REDEVELOPMENT OF HARBOURSIDE SHOPPING CENTRE

SSD16_7874

Public Submission

Kerry Keogh

Very large floor plates at
RL41.9, RL54.5, RL 74.5

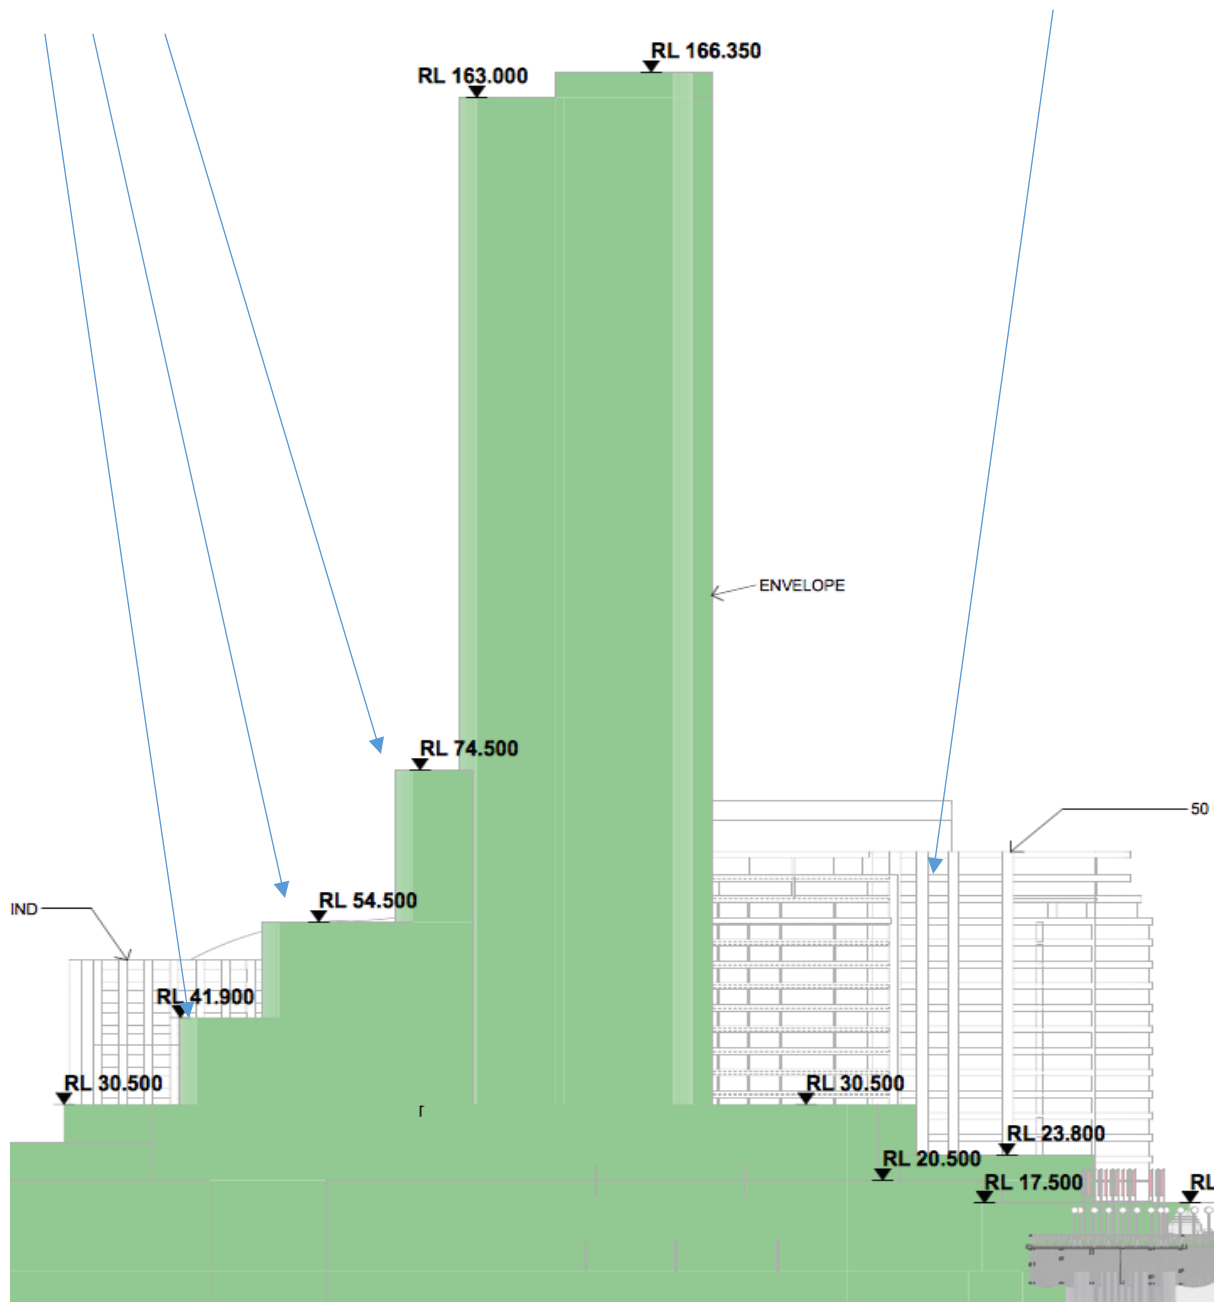
The proposal's is for a non-residential platform of varying RLs from 30.5 to 17.5. On top of this platform it is proposed to put several floor plates of residential at RL41.9, RL 54.5 and 74.5, before a further tower element to RL 166. In fact the proponent has a tower on a very large platform which a tower sits on; the tower is set back at RL30.5, again set back at RL41.9, again set back at RL54.5 and again set back at RL 74.5. To put this in context, the height at which the tower is set back at RL74.5 is well over the height of One Darling Harbour.

The bulk and scale of the tower in particular contrasts with the lower scale character of the Darling Harbour precinct and therefore is visually quite dominant and compromises and unsympathetic to the established valley floor character. The massive floor plates are totally unacceptable. The proponent states the floor plates are some 1,000sqm but this is at the top of the tower. They are massive floor plates lower down as the set backs take effect. This is a residential development and not a commercial commercial as before where floor plates of up to 1,200sqm are acceptable. The Department often quotes that residential towers should not exceed a floor plate of 600-800GBA and this should certainly be the limit in this sensitive area of Sydney.

I consider for these reasons The 'wings' of the tower element are not acceptable and should not be supported and the Tower floor plate above the shopping centre platform not exceed 800GBA with a maximum width of 25 meters.

Figure 2.7: Envelope Plan – Tower (Source: FJMT, 2020)

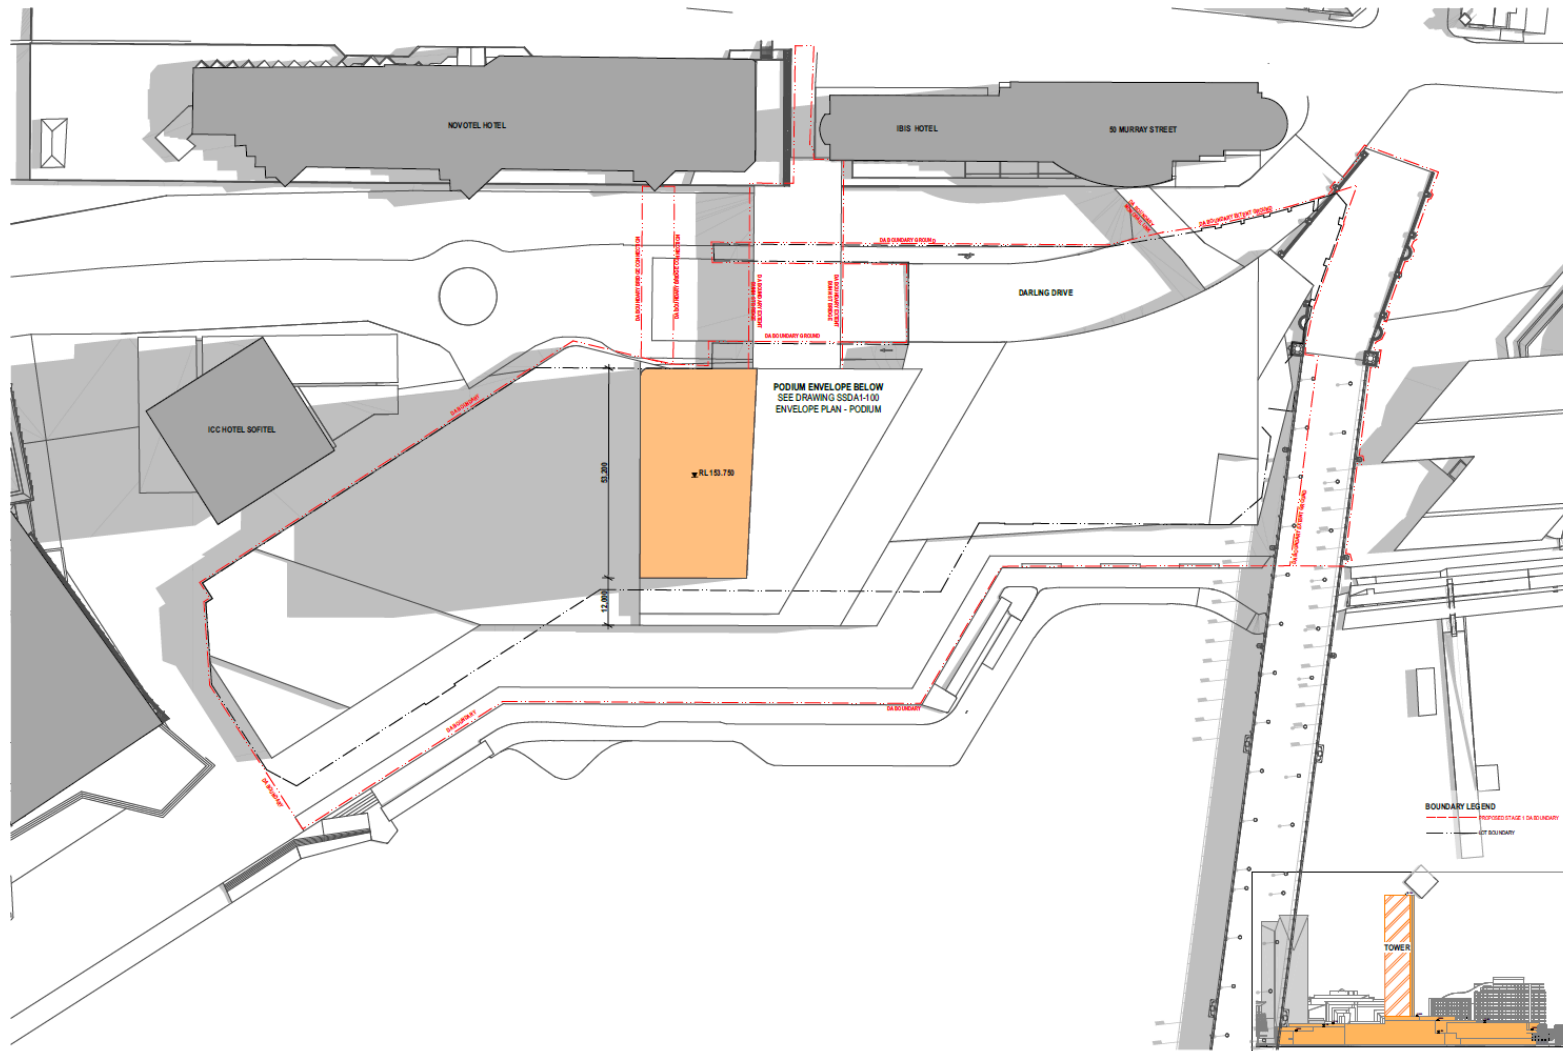
In the current location it is the lower large floor plates of the tower at heights of RL74.5, RL54.5 and RL41.9 that causes the severe loss of views and their removal, consistent with a slim tower, would enhance the outcome for all concerned.
